Online Comment

Application H14-0020-24
Location The Yews Farm Land off Spalding Road Pinchbeck PE11 3UE
Proposal Details of site levels & floor levels, construction management plan & method statement, estate road phasing & completion plan, adoptable estate roads & footways, surface water drainage scheme, on-site foul water drainage works, cycle store, acoustic barrier, landscaping & tree planting, boundary treatments, management plan for areas of publicly accessible open space & outdoor play areas, management & maintenance schedule, additional elevational treatments for plots 1, 2, 11, 67, 68 & 69, external boxes for gas & electricity supplies, gas flues & soil vent pipes, preliminary ecological appraisal, swift next bricks, biodiversity management plan, local area for play (LAP) & water consumption (Conditions 3, 8, 9, 10, 11, 12, 13, 14, 15, 16, 17, 18, 19, 20, 21, 22, 23, 24 & 25 of H14-1218-21)

Name Annette Faulkner - Lincolnshire Bat Group
Address 65 London Road Spalding Lincs PE11 2TN

Date Submitted 01-02-24
For/Against Objections

Biodiversity Management Plan

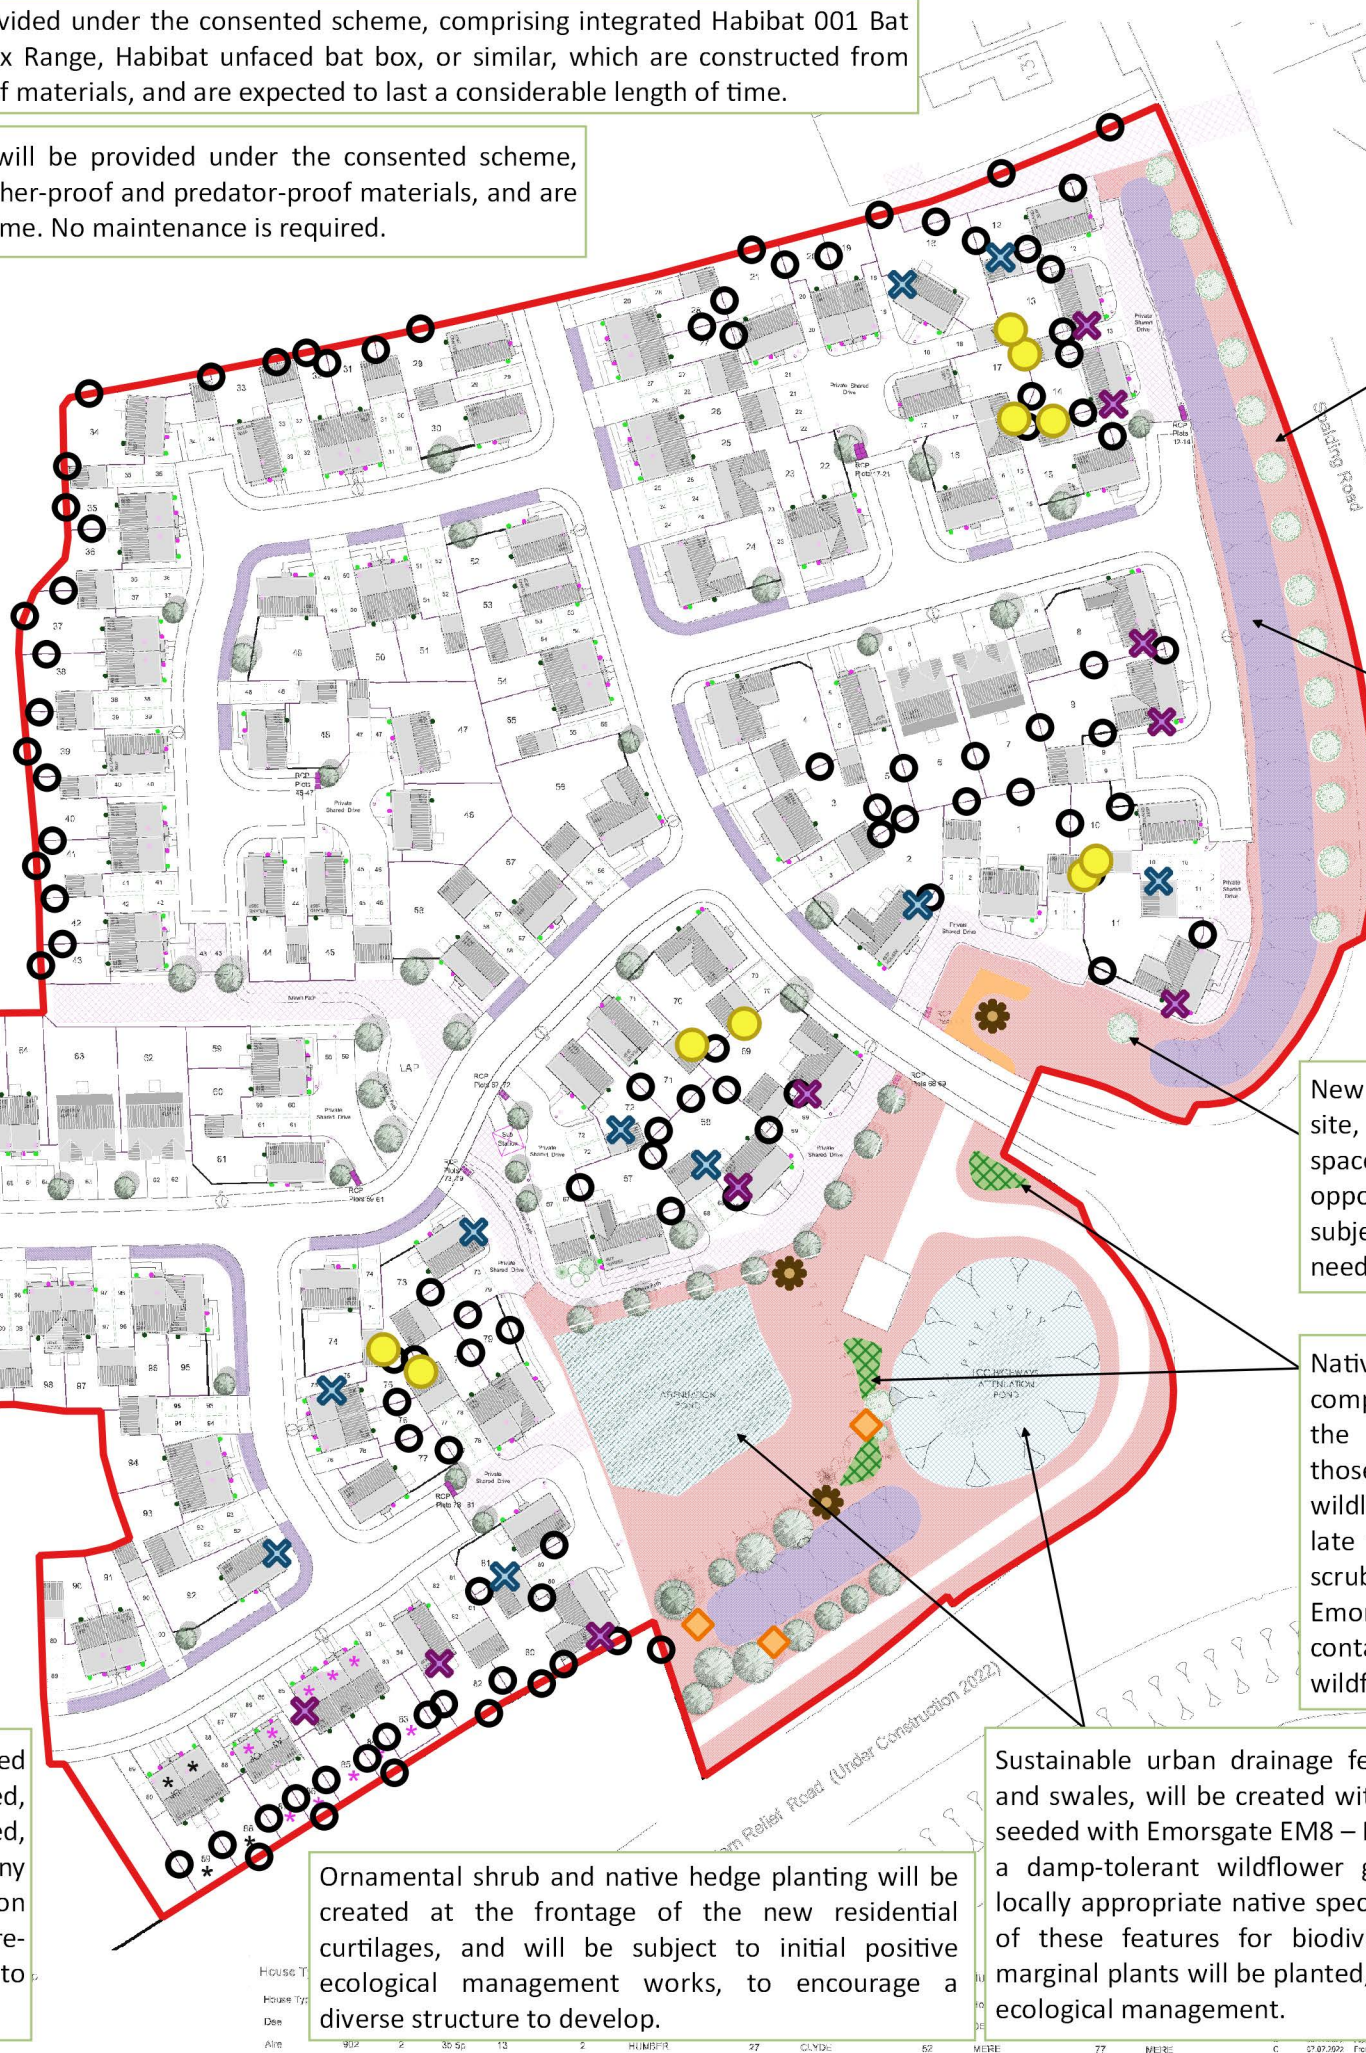
Thank you for consulting Lincs Bat Group on the Biodiversity scheme. With reference to bat boxes, pleased to see they are to be integrated into the buildings, but 10, for a development of this size?!

Two objections: one, there should be at least three or four times that number; and two, they should be sited well into the estate and well away from the existing and new busy main roads, given that there is the river to the south and mature gardens - which are of enormous and frequently unconsidered important feeding areas for foraging bats - across Pinchbeck Road, which any bats are much more likely to cross if boxes are sited nearby, and risk being hit by cars. The gardens within the estate will themselves become important habitats as they develop. This doesn't appear to have been considered.
